Draft Report on the Proposed Armidale Regional Landfill Proposal

This Report contains commentary and analysis on the Environmental Assessment dated April 2010 and the Submissions Reports, dated October 2010 and April 2011 undertaken by AECOM on behalf of Armidale Dumaresq Council (ADC). The information from the aforementioned documents was supplemented by a site visit on 22 December 2010 and various meetings with the Department of Planning representatives in Sydney.

ARMIDALE LANDFILL		
LANDFILL FOOTPRINT		
STATUS:	DRAWING NO:	REV:
DETAILED CONCEPT	20017605-CI-102	A

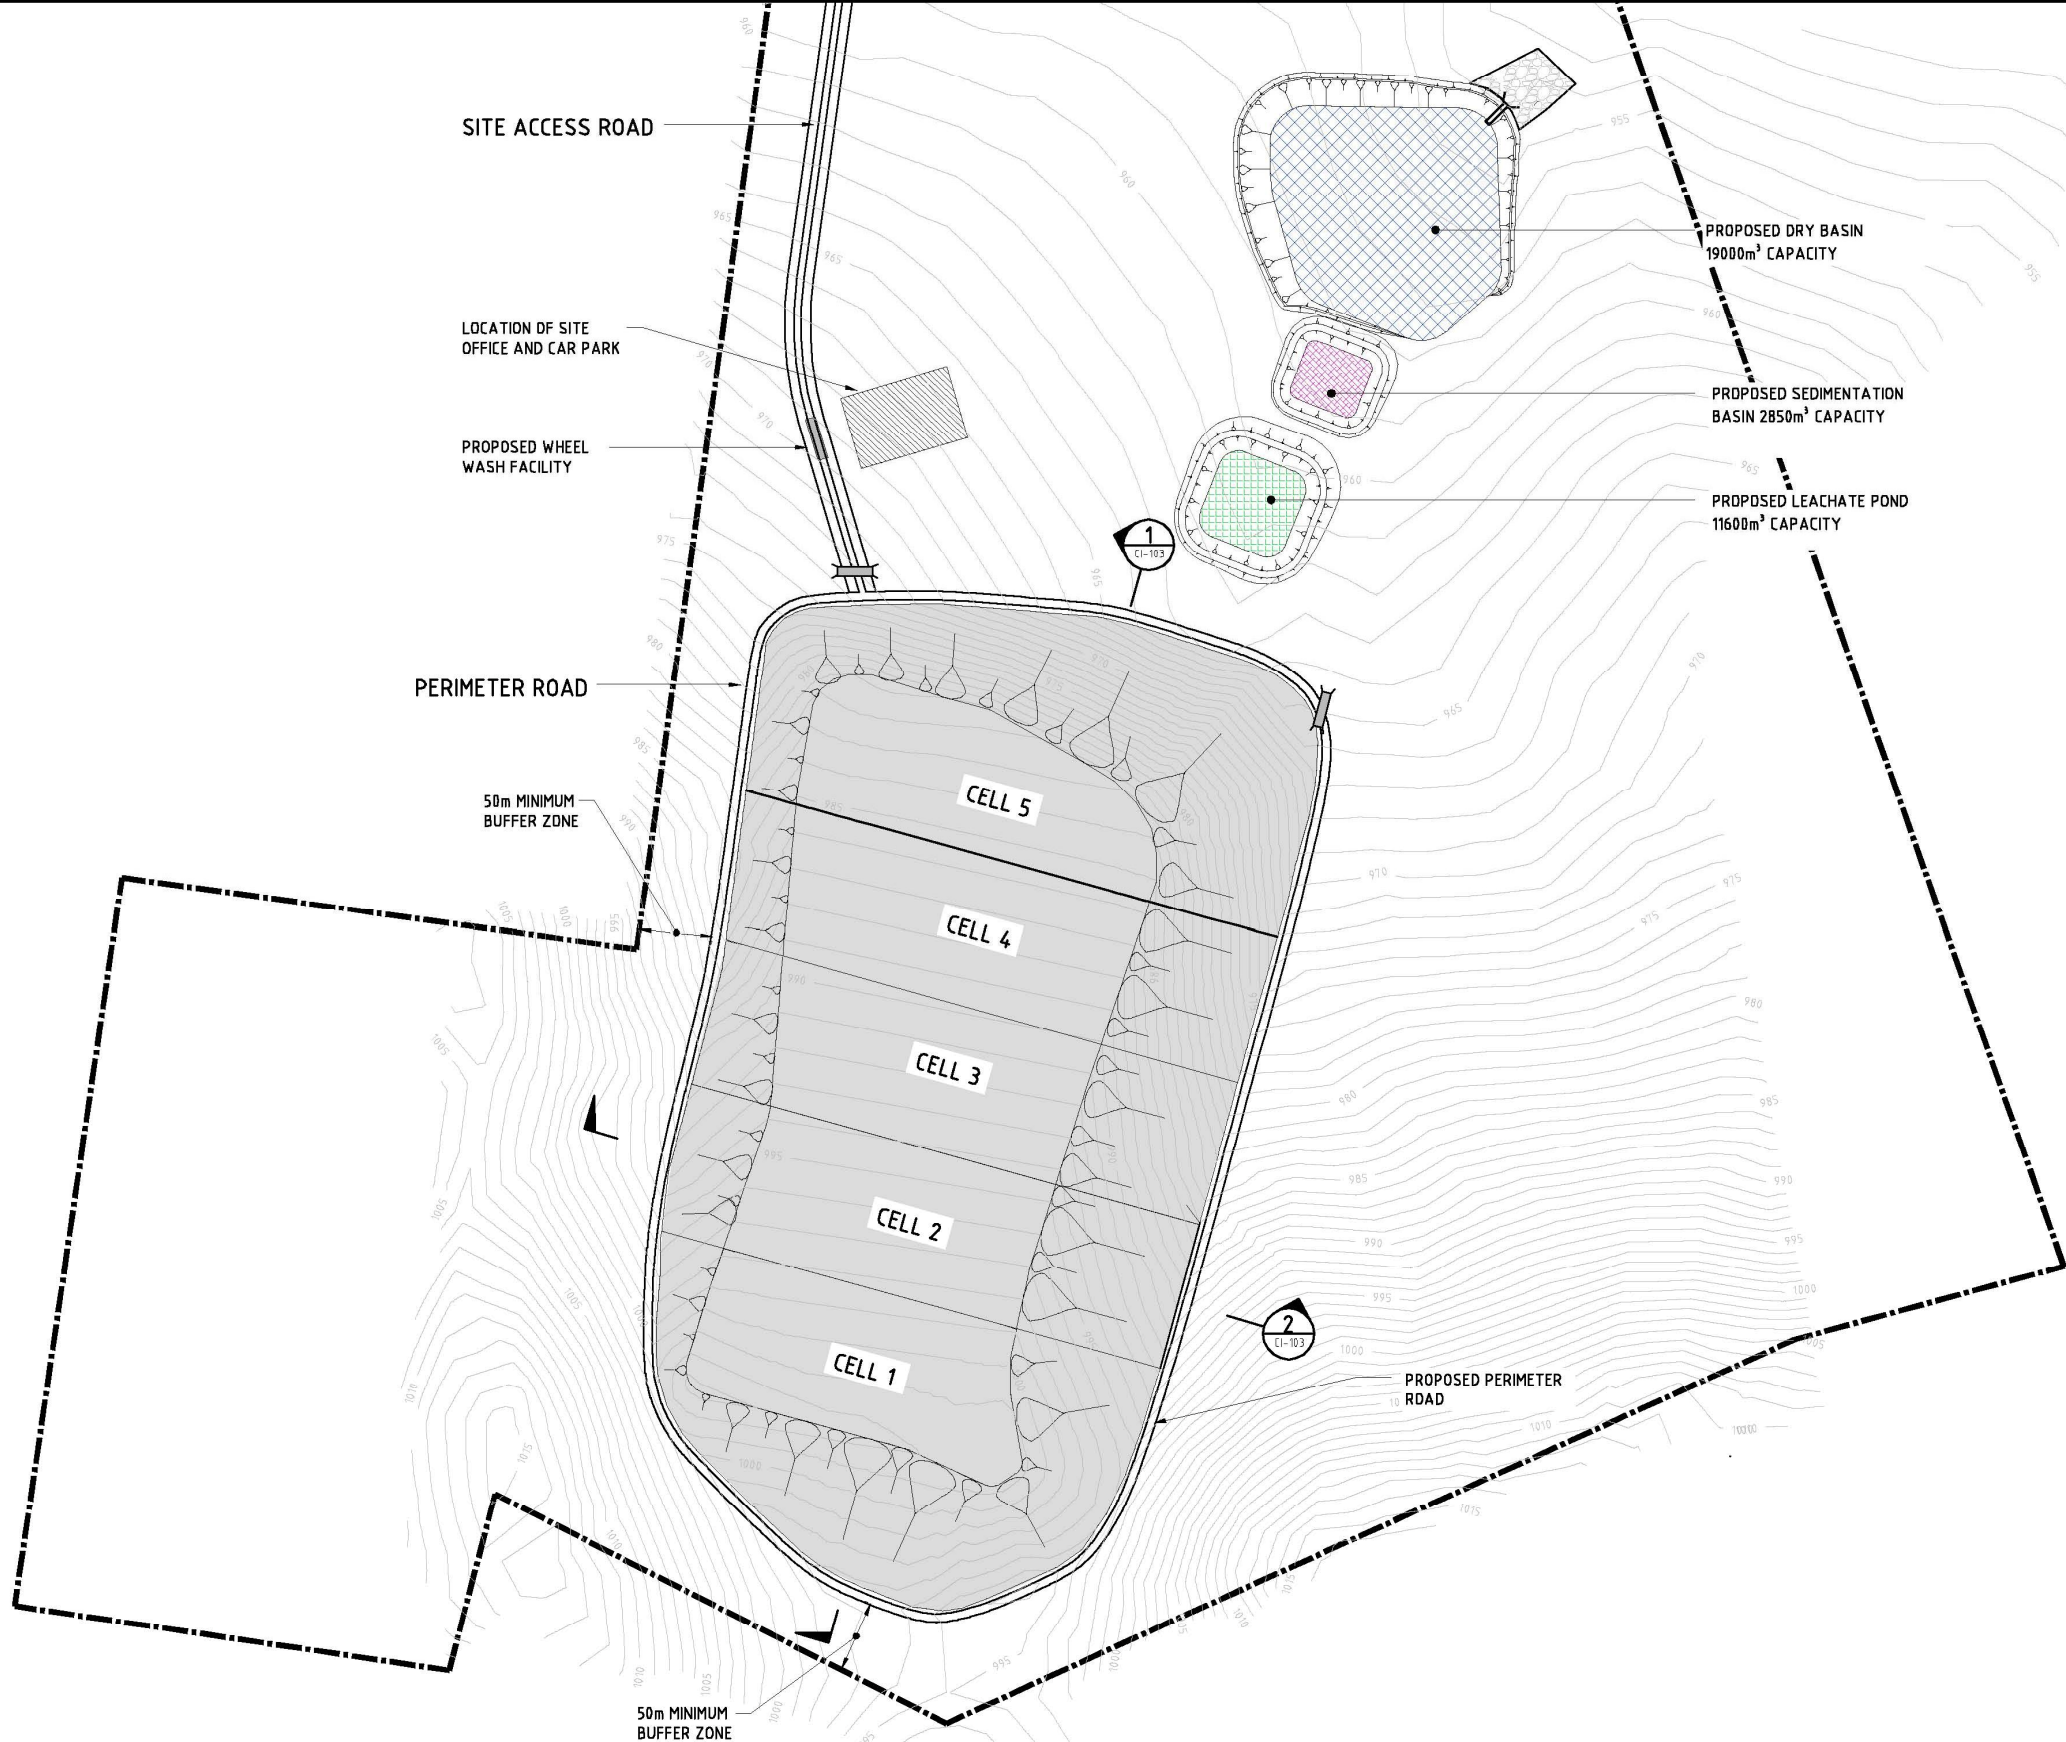
It is therefore considered that approval should be given for **Cells 1 and 2** of this Project, each containing a total of 211,000 cubic metres of waste and cover material (Page 51 of the EA). This would give the ADC a total landfill capacity of **422,000 cubic metres**, which is estimated in the EA to last at least 20 years. However it is likely that this life could be extended to at least 25 years with improved recycling, better waste minimisation and greater landfill compaction.

TYPICAL BASE LINER DETAIL
NOT TO SCALE

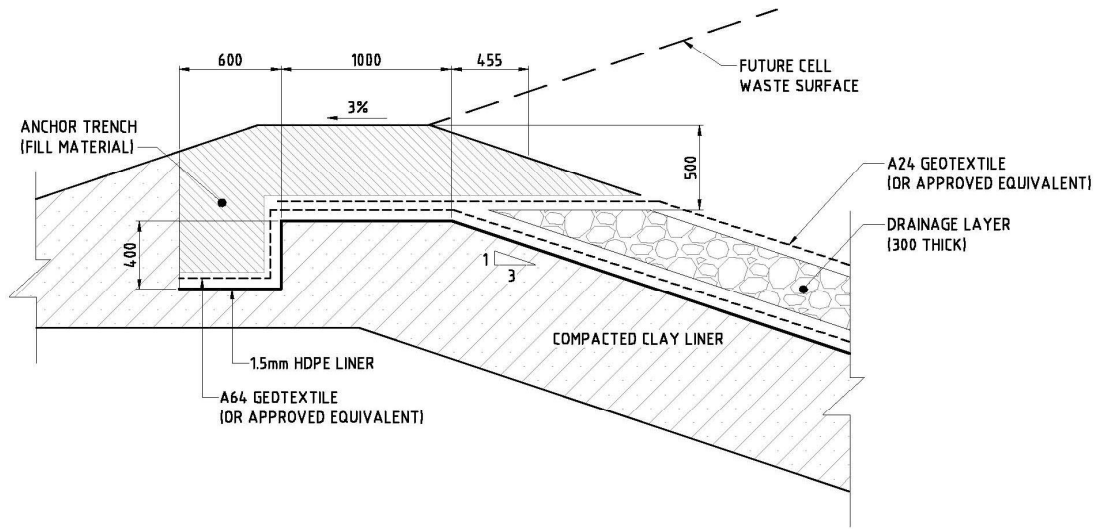
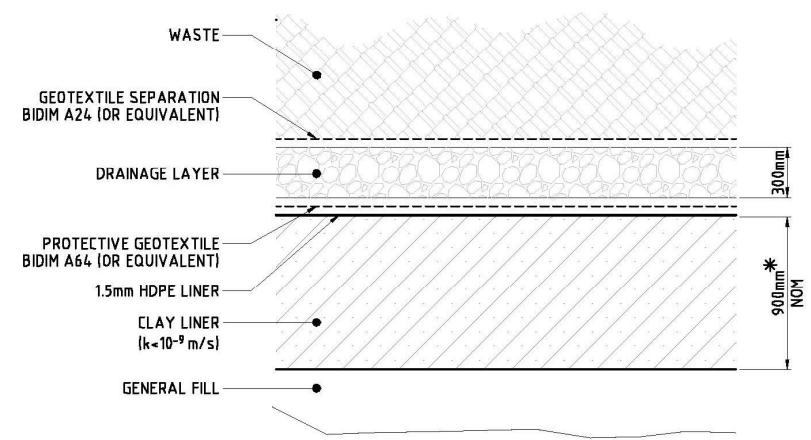
The combined 'double liner' of compacted clay and HDPE Plastic proposed for the Armidale Regional Landfill is of a standard greater than that required under the standard Benchmark Technique for solid waste landfills.
